**Consultation Response from KC,
Highways Development Management**
2020/93954 Land at, Lingards Road, Slaithwaite, Huddersfield, HD7 5HY
Erection of 57 dwellings and associated works
**Date Responded:
12/01/2021**
**Responding Officer: Mark
Berry**
Responding Ref: 1-32-20

This application seeks approval to the erection of 57 dwellings and associated works at land at, Lingards Road, Slaithwaite, Huddersfield.

ROAD 1

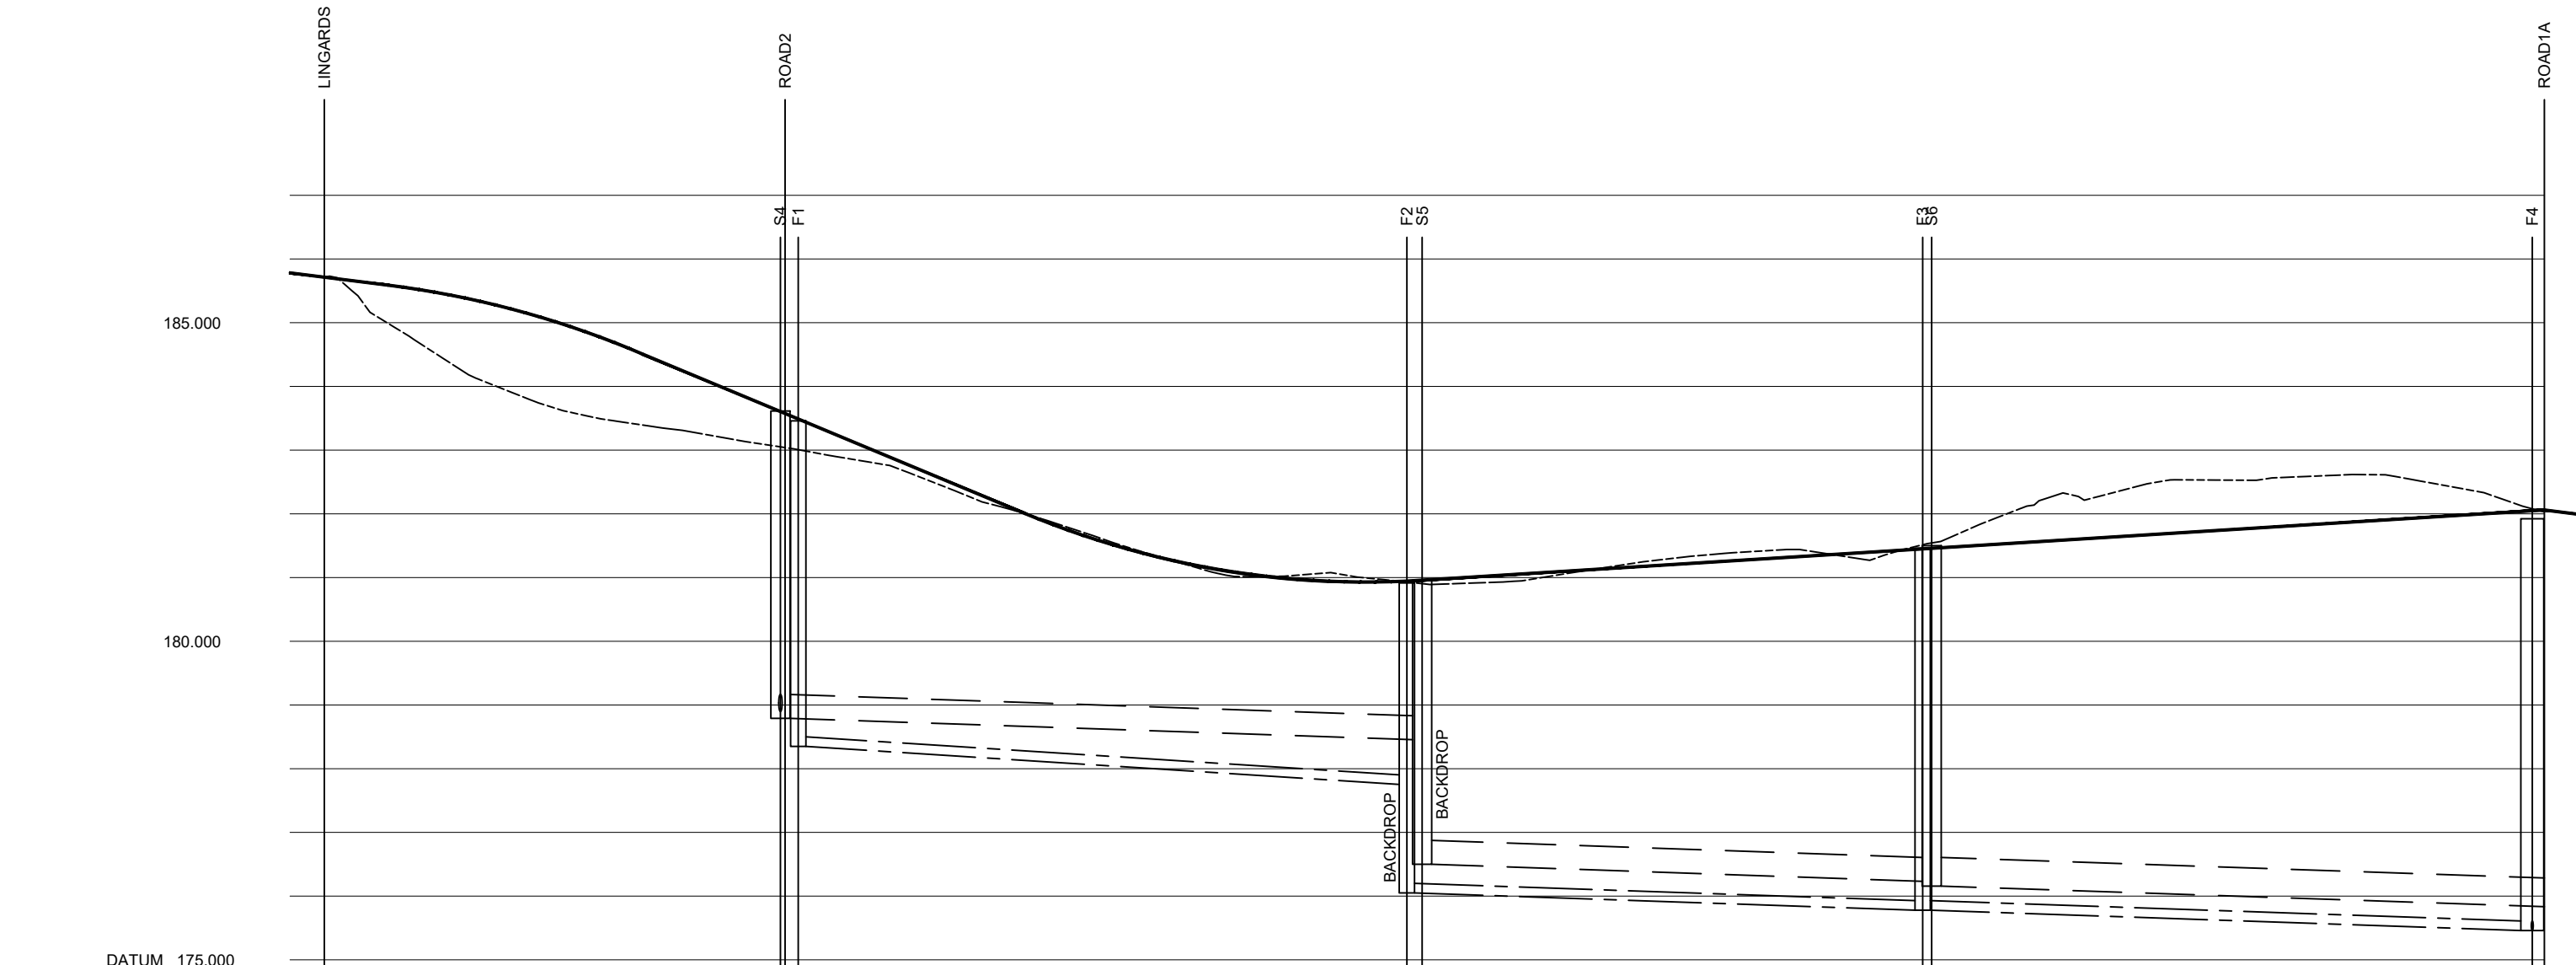
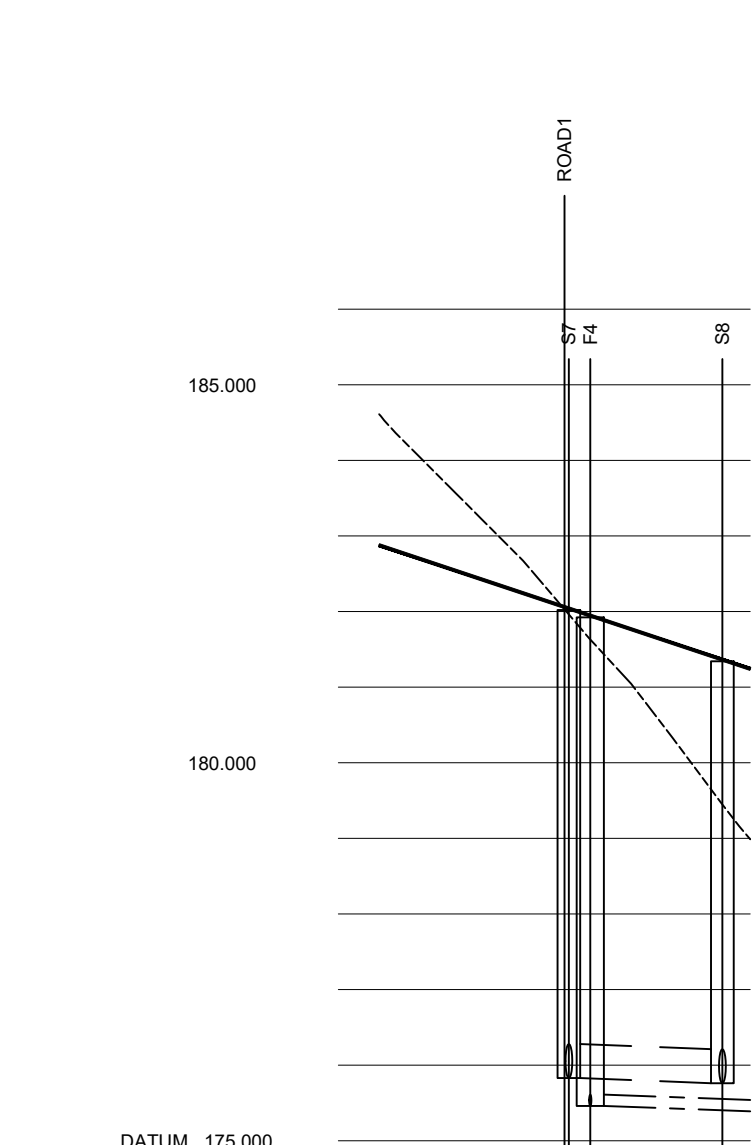
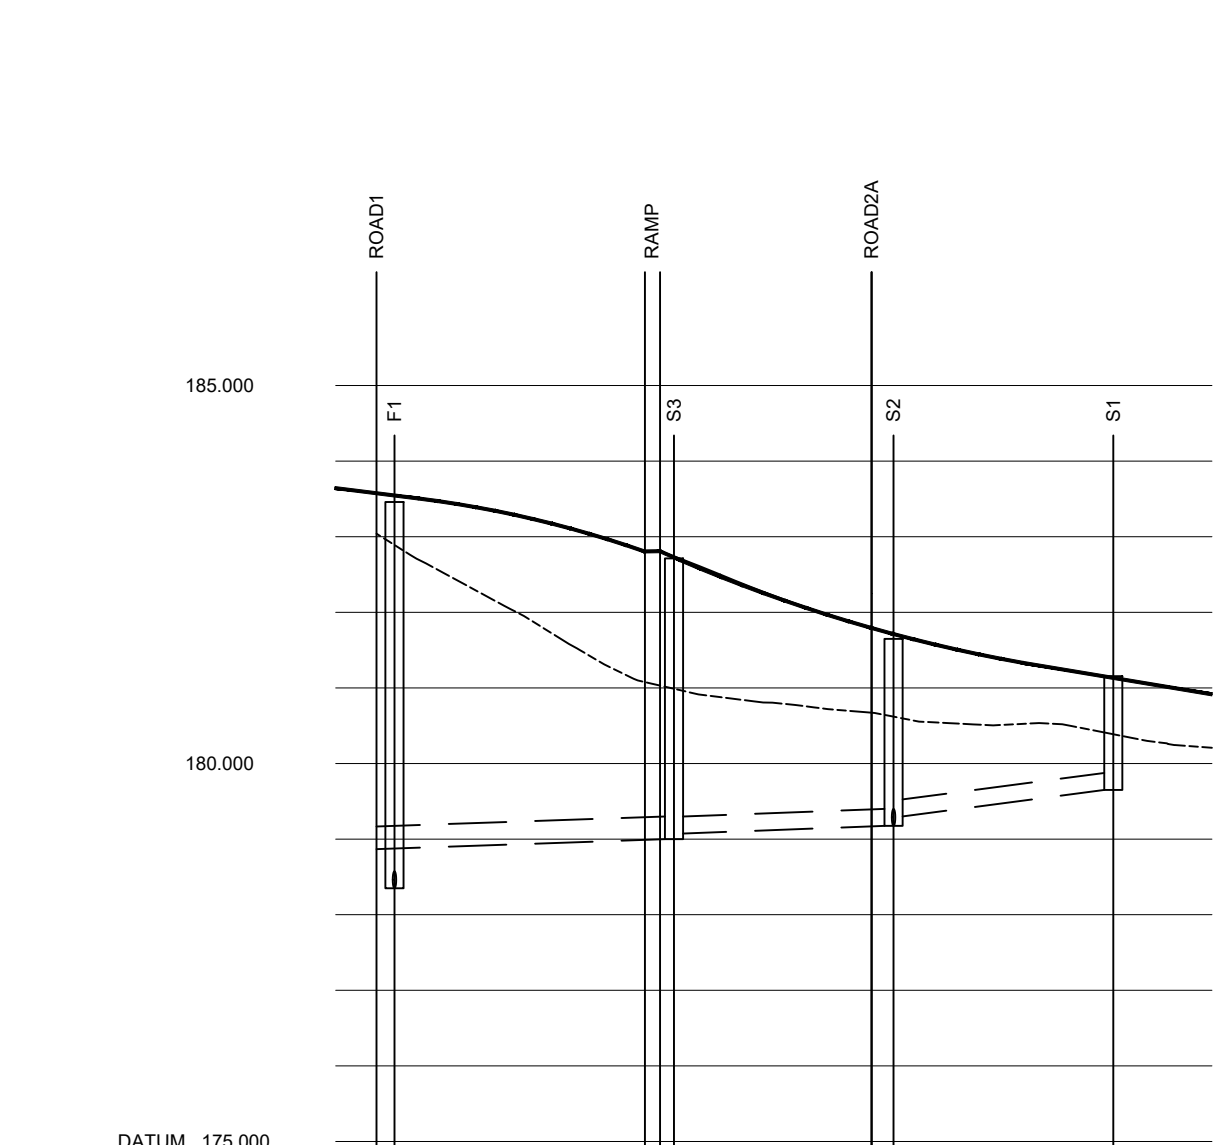
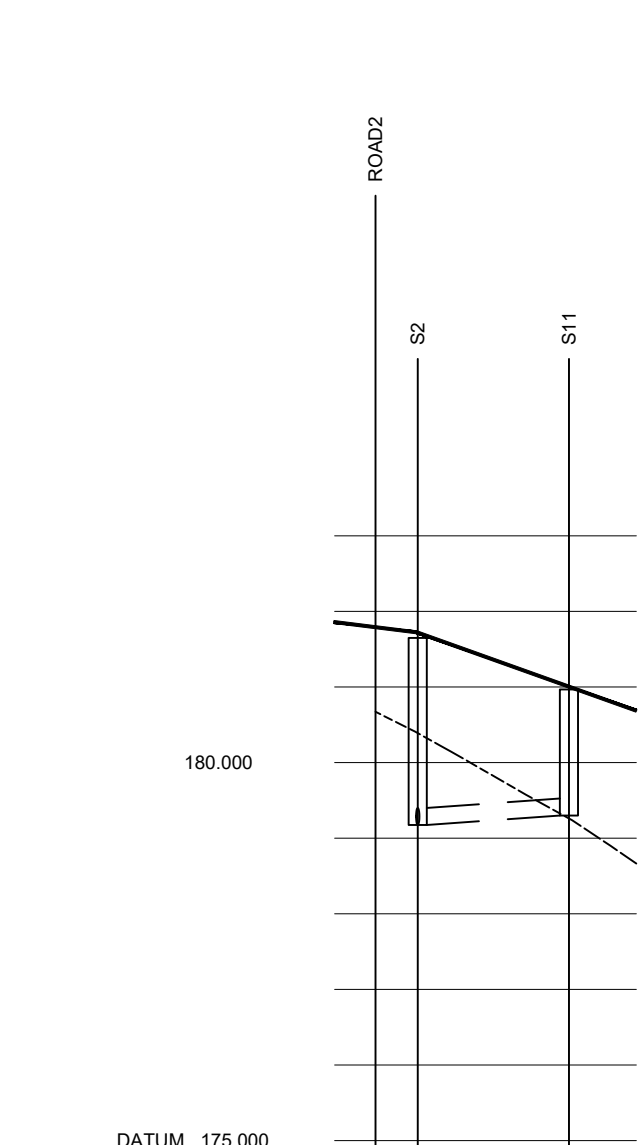
- 1, A layout plan showing the house types and plot numbers should be provided to enable an assessment of the proposed parking to be undertaken.
2. No longitudinal sections are provided to allow the proposed road gradients to be assessed.
- 3, The plan showing refuse vehicle swept paths is superseded but a revised plan as not been provided. The Coda site access and refuse vehicle tracking plan shows the refuse vehicle over-running kerb lines which is not considered acceptable.
